Rezoning Transportation Analysis

Petition Number: #2022-091

Date	Description
11-28-22	First Review (IW)
01-27-23	Second Review (IW)

RZ-1.0

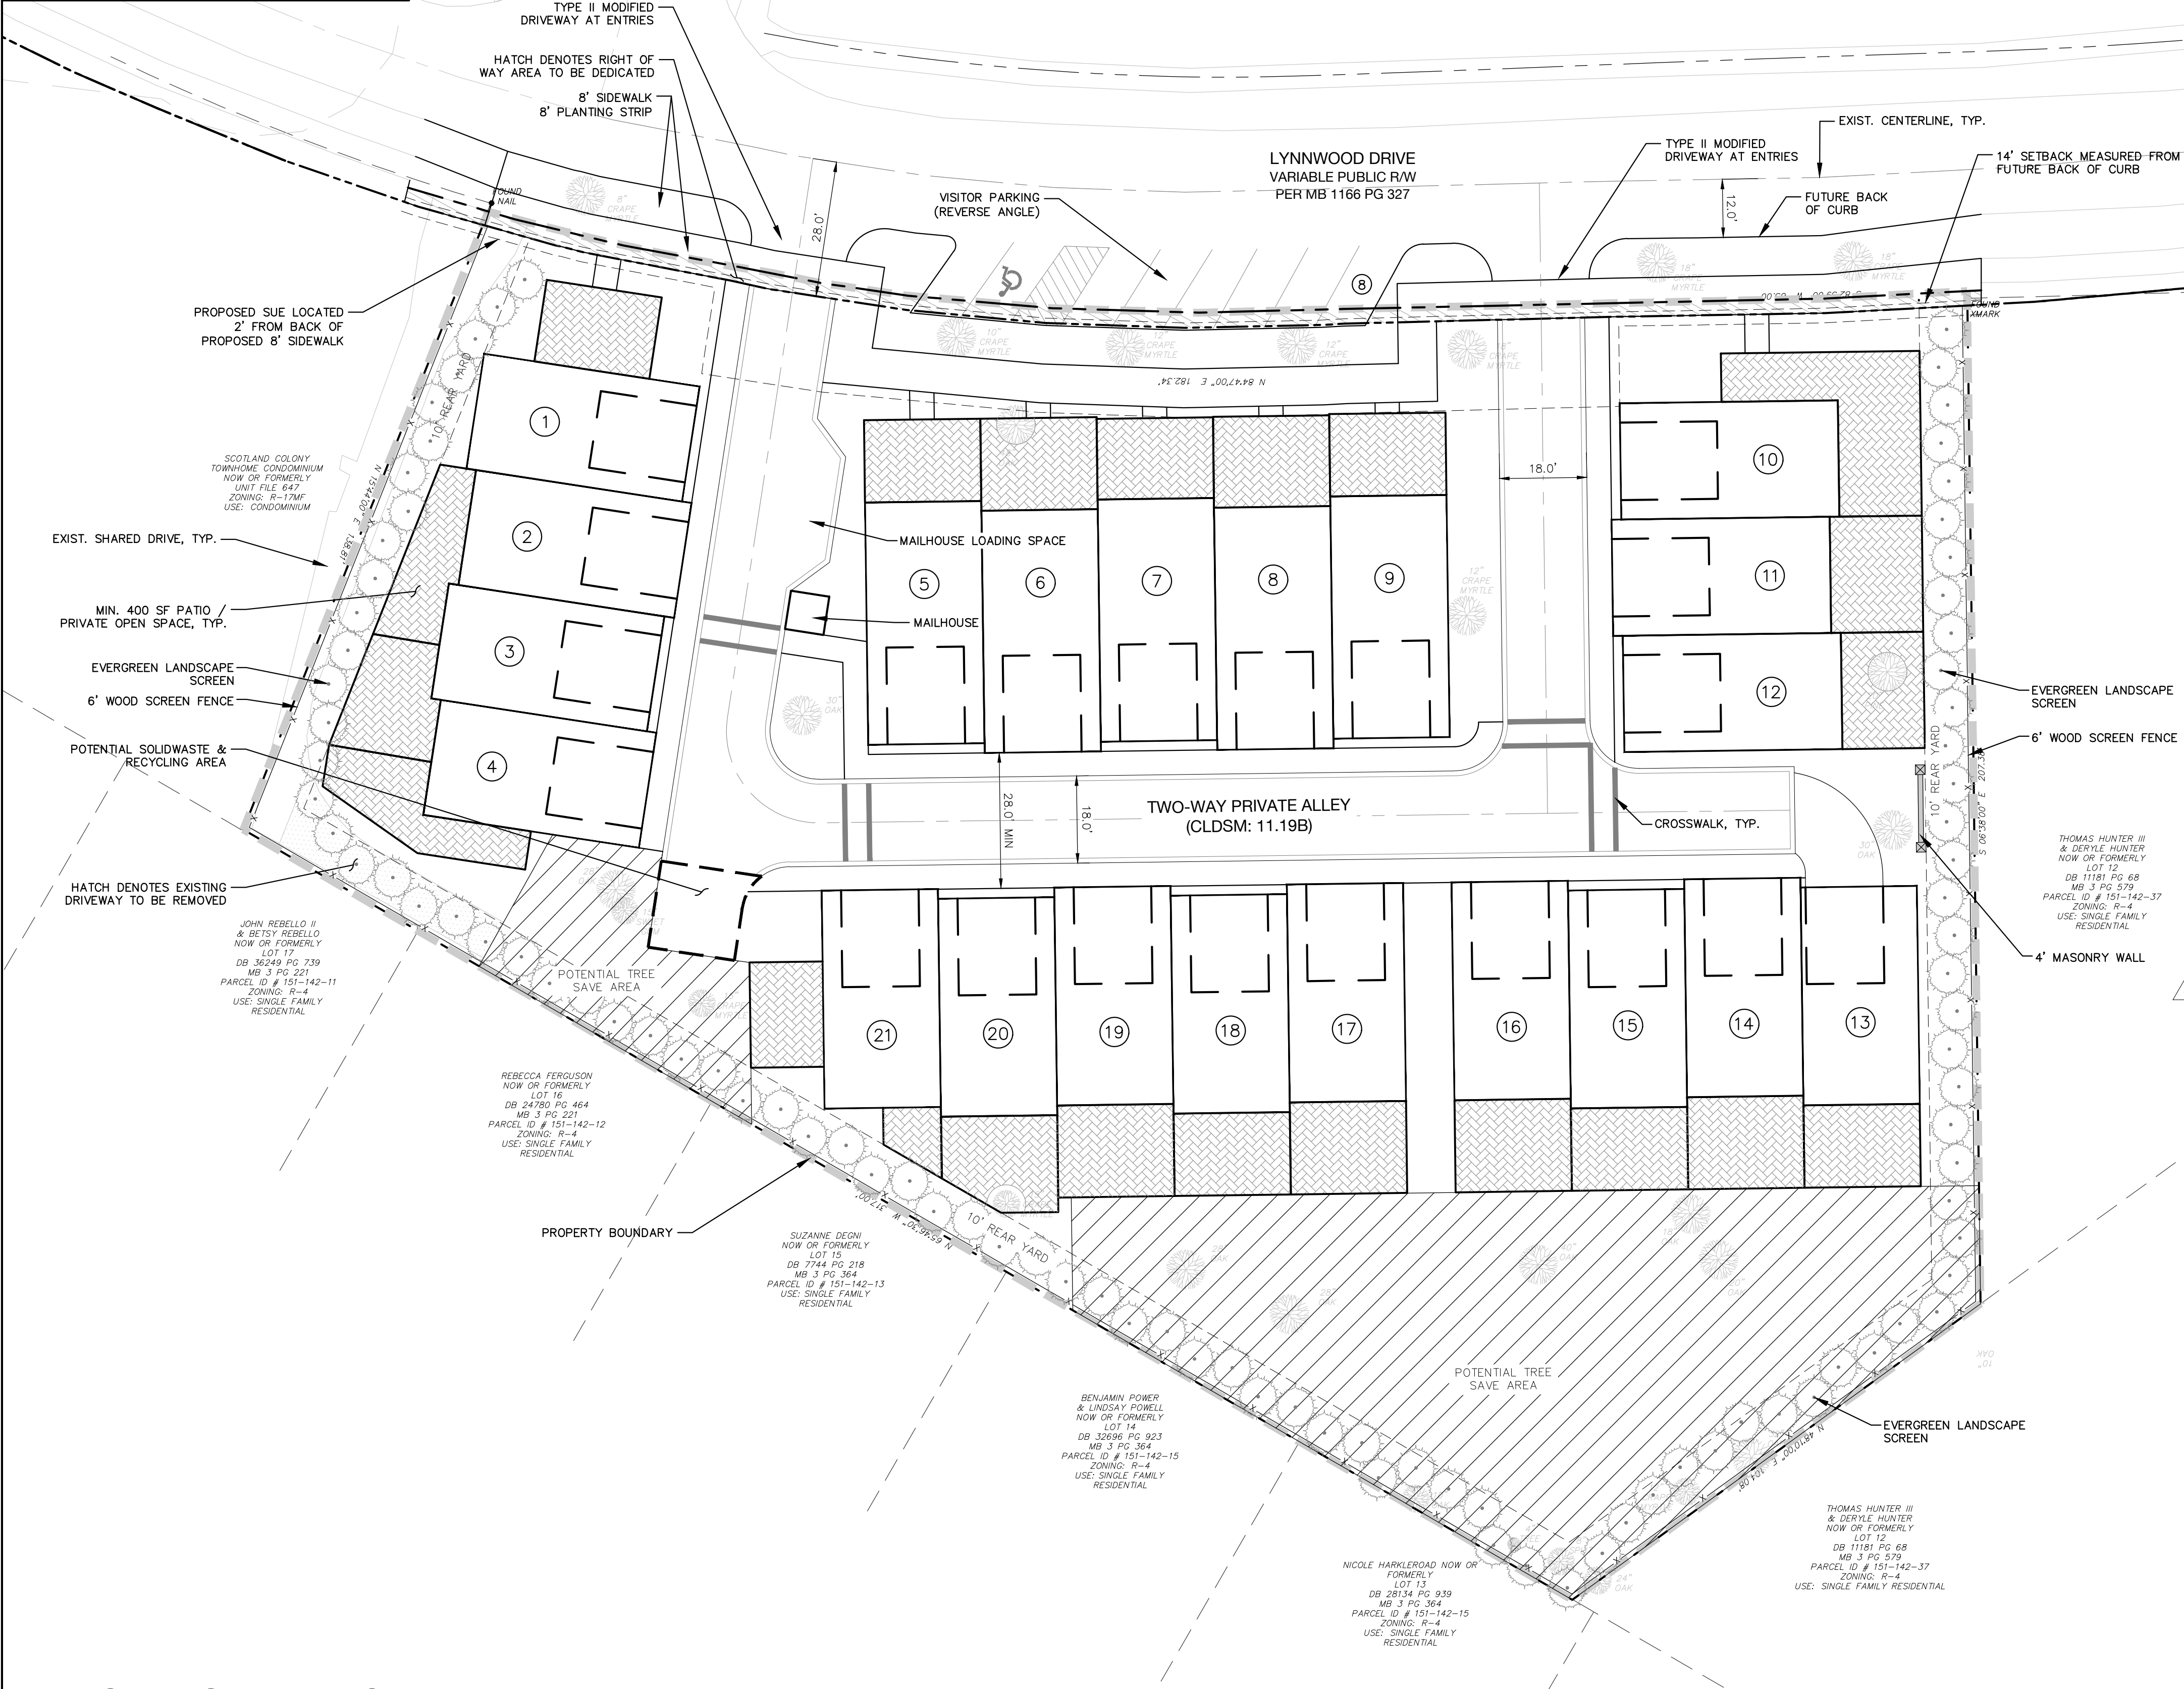
- Outstanding comment from 11-28-22 Curblin****e**: The proposed zoning district has a setback measured from back of the existing or proposed future curblin**e**.
 - Lynnwood Drive**: The future location of curb and gutter should follow the CLDSM Local Residential Medium Street which is measured at 13-feet from the centerline of the roadway to the BOC.
Clarifying comment 01-26-23: Site plan should show dimension from centerline to back of curb.

Label and dimension the curb and gutter from the centerline for each road on the site plan.

Comment Clarification 01-27-23: CDOT is comfortable with the reverse angled parking given context of the existing street network and neighborhood development. Add conditional note stating that appropriate signage for reverse angle parking will be coordinated with CDOT during permitting.

7. **Outstanding comment from 11-28-23:** A site plan note(s) specifying dedication and fee simple conveyance of all rights-of-way to the City before the site's first building certificate of occupancy is issued as needed. CDOT requests rights-of-way set at 2' behind back of sidewalk where feasible.

Clarifying Comment 01-27-23: Site plan should update conditional note 7 under Transportation to state SUE to be 2' behind sidewalk and not 1' so that CDOT can do maintenance when necessary.
